RE APPLICATION NO. 2016/0169

LOCATION- LAND AT WENTWORTH STREET, BARNSELY, S70 5UN

We are writing to object to the proposed plans for the land at Wentworth Street, Birdwell and the construction of 14 dwellings.

Appendix 5:
Tree Constraints Plan
 Wentworth St, Birdwell, S70 5UN
 Ref: AWA1554

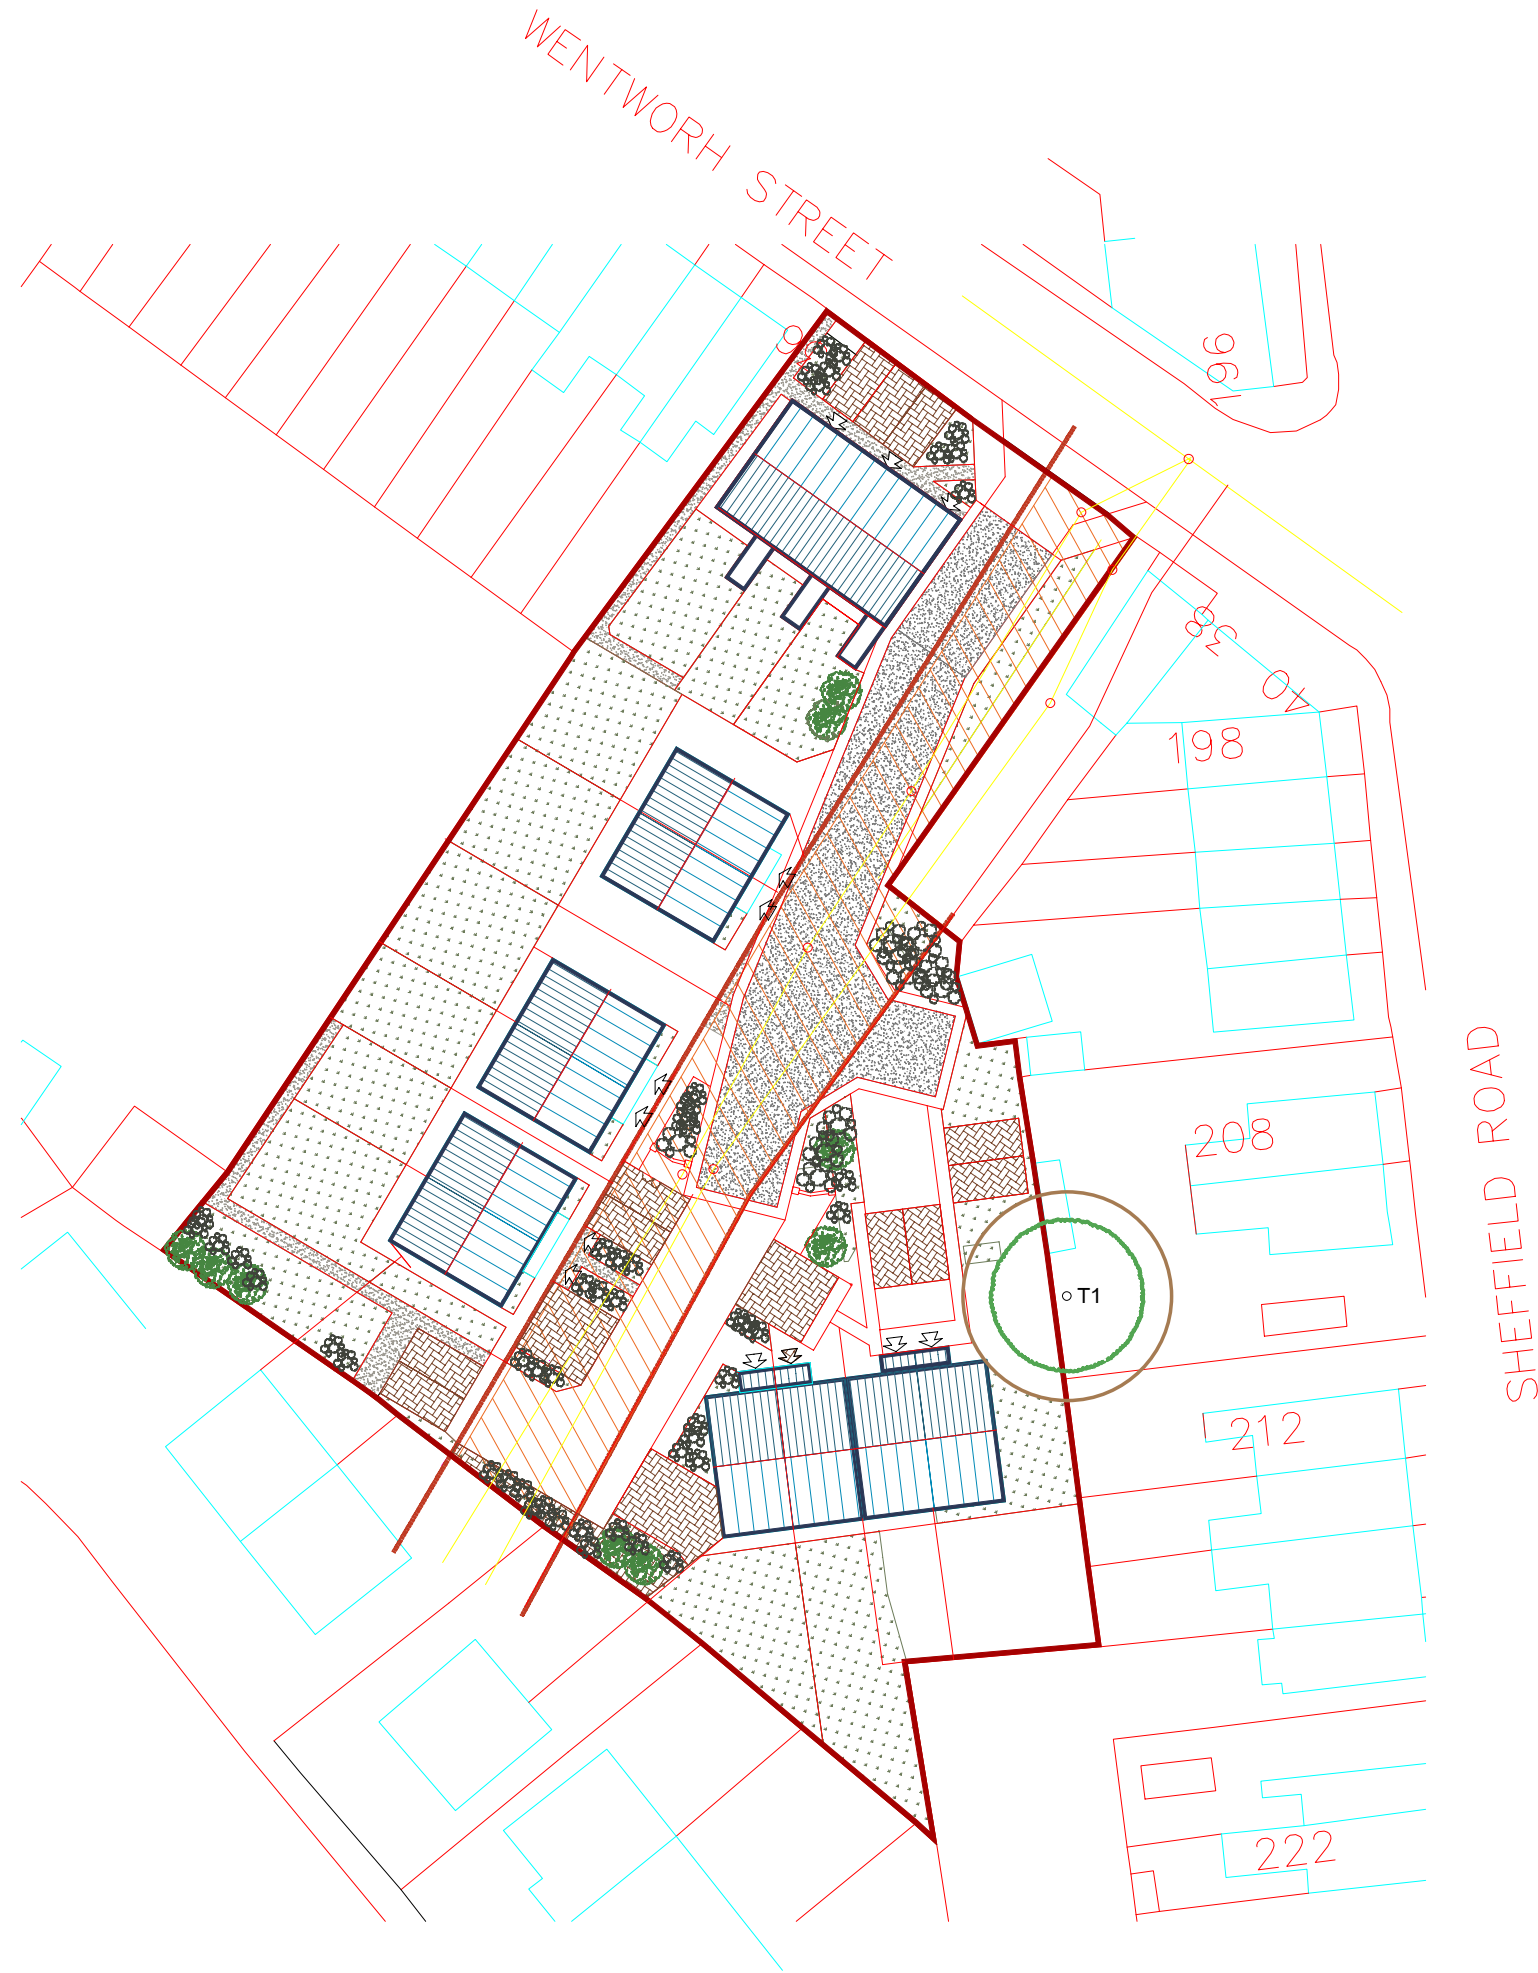
The Design and Access statement states that "there are no trees or water features on the site". This is incorrect, as there is a large Poplar tree situated on the site which is proposed for development.

Please clarify what will happen to the tree, and why the Design and Access statement has been received when it is not factually correct.

| PLANS AND ELEVATIONS PLOTS 6 - 9 | | AUGUST 2015 | | 1:100 @ A2 | |

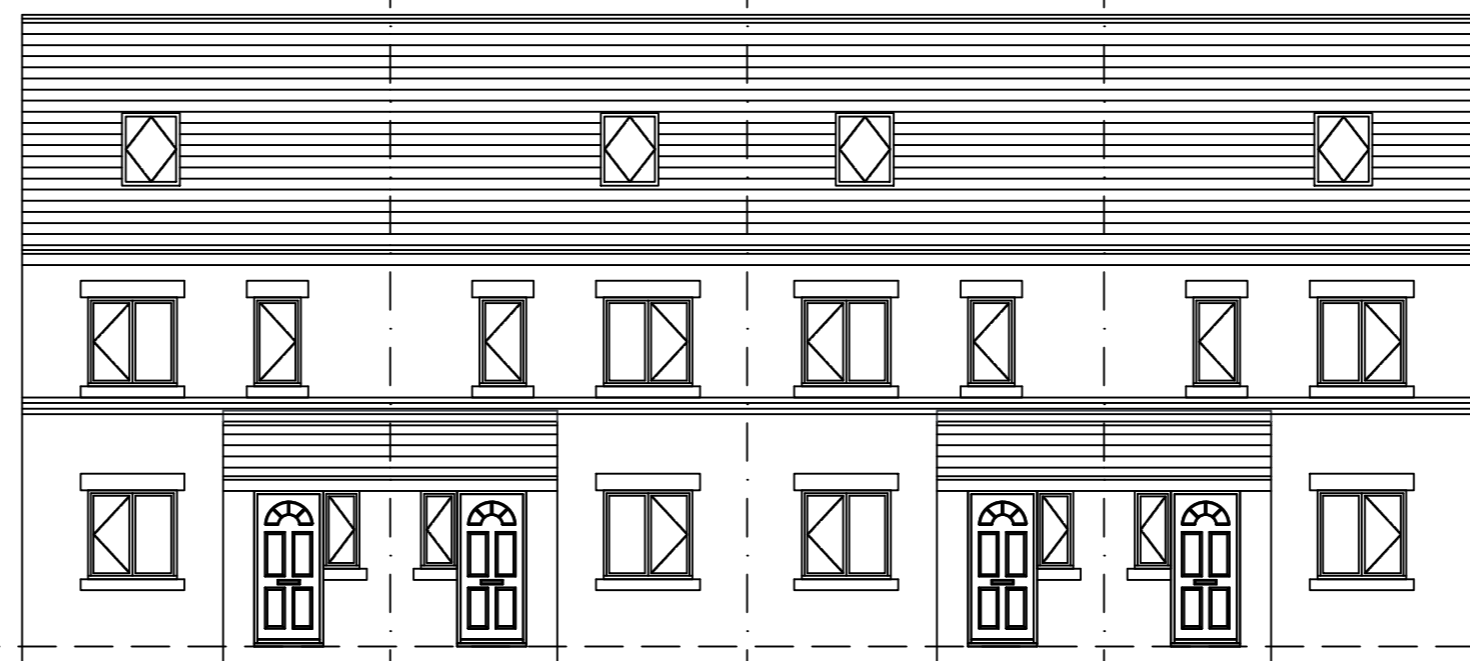
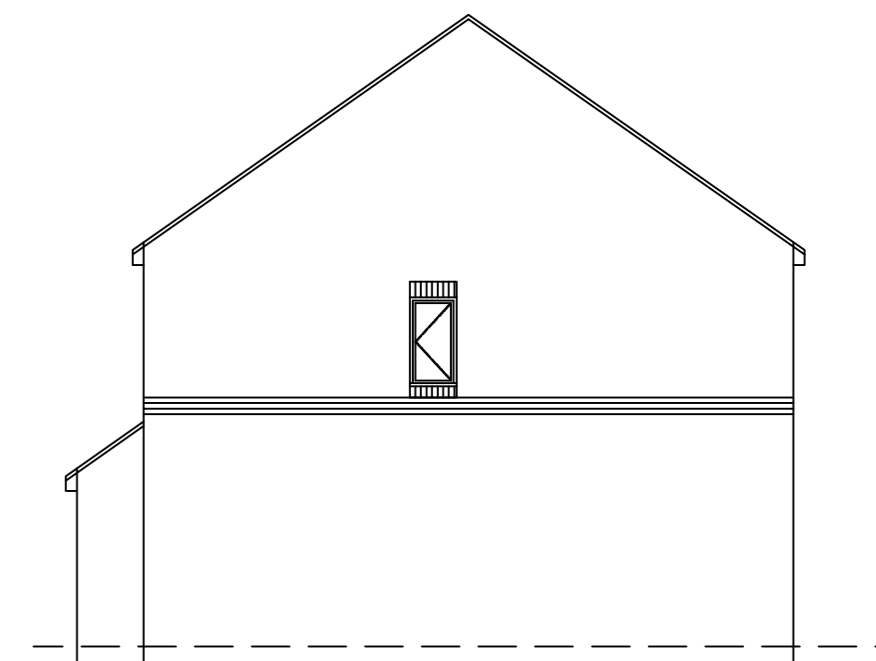
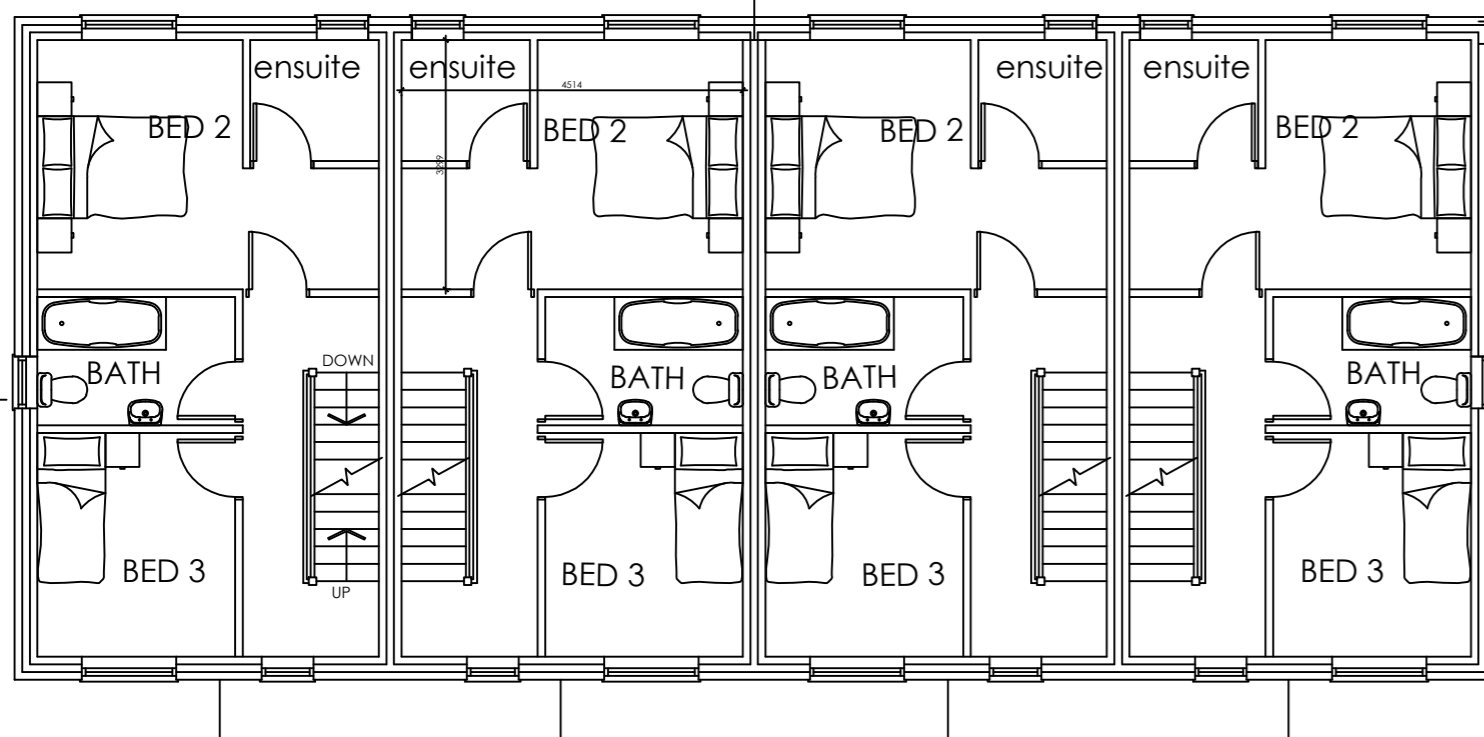
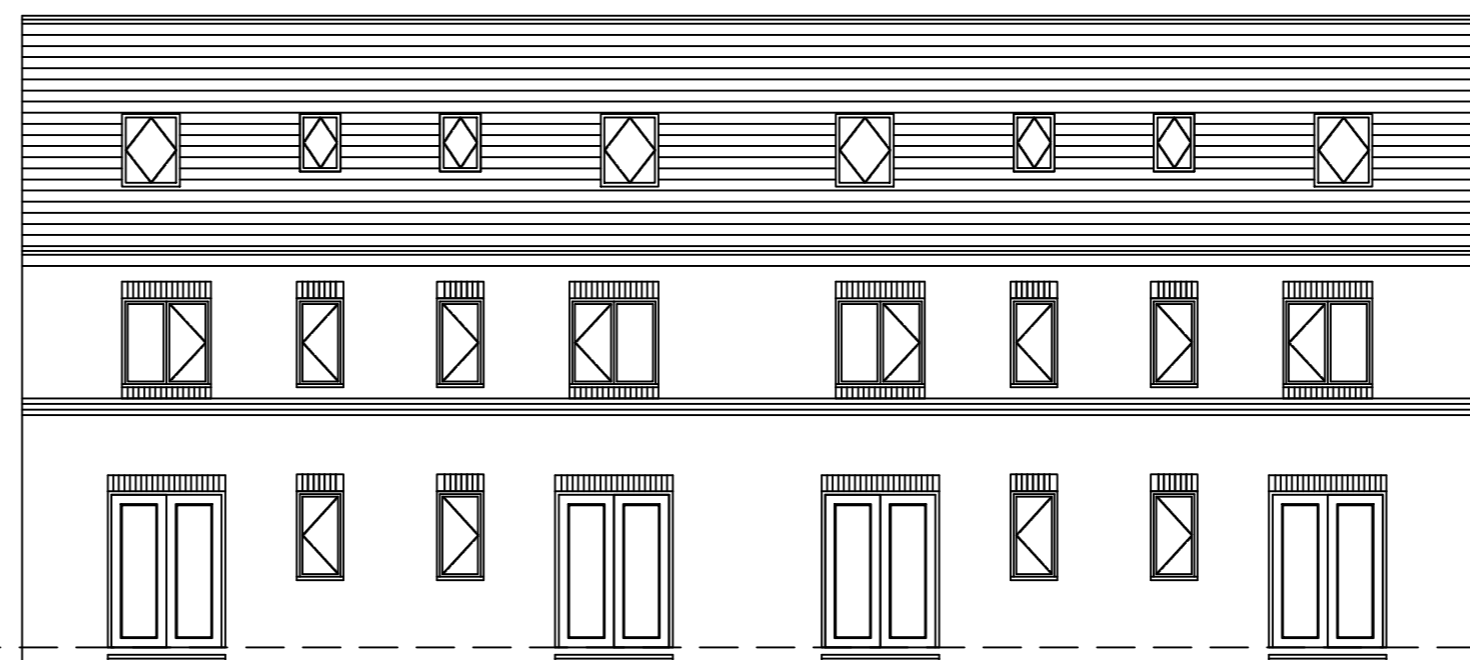
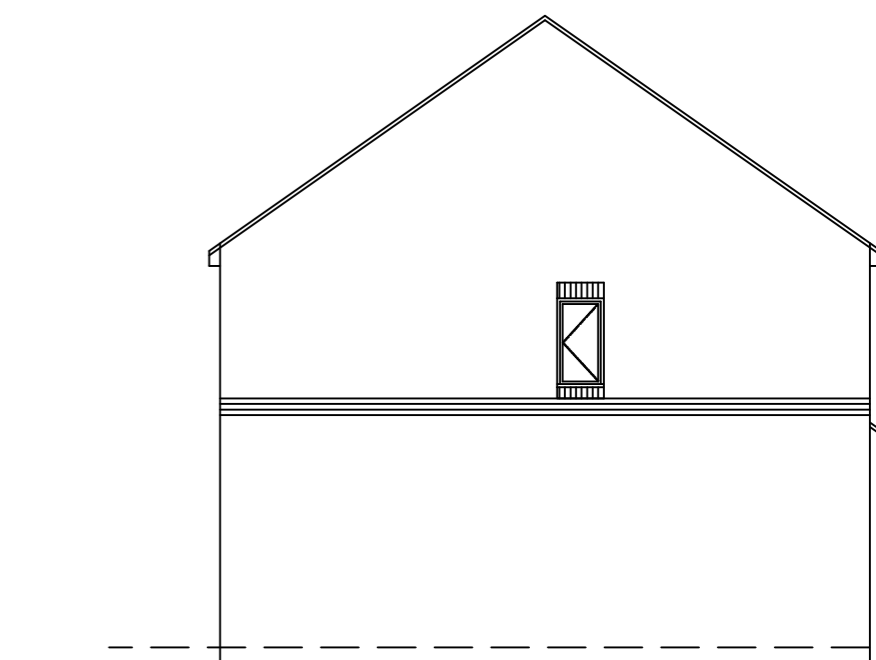
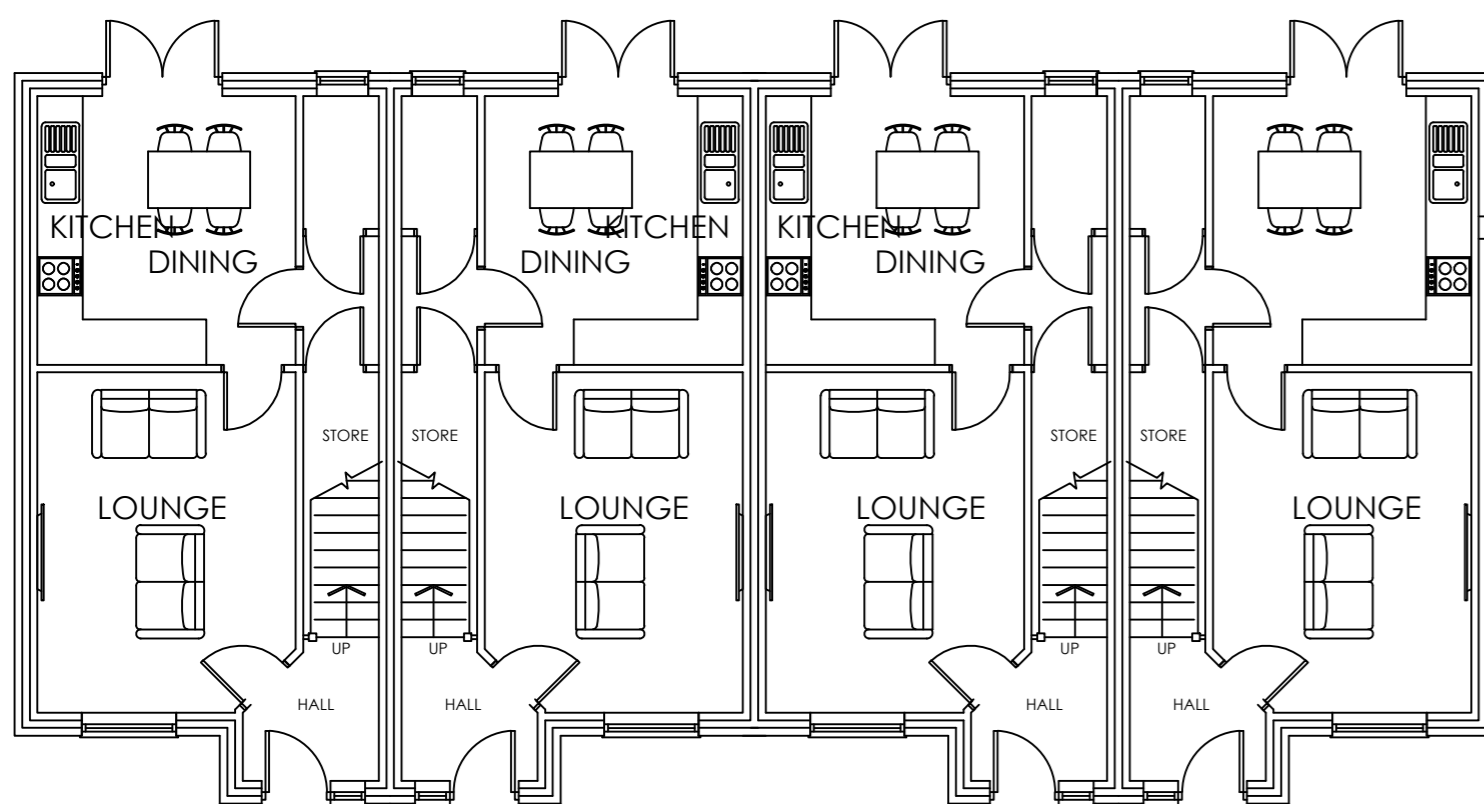
In the proposed plans, plot numbers 4-7 will have windows which look directly onto the back elevation of our property.

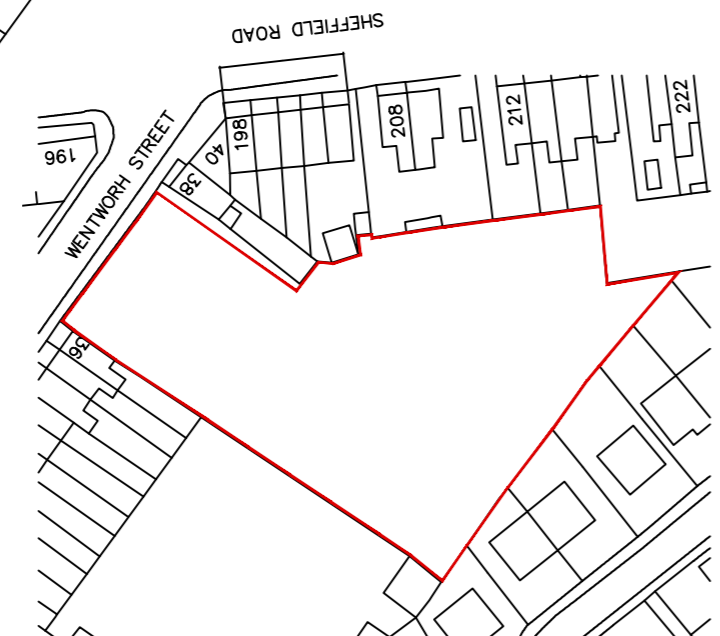
Our master bedroom and bathroom are on the back of the house. This will have a significant impact on our opportunities for privacy.
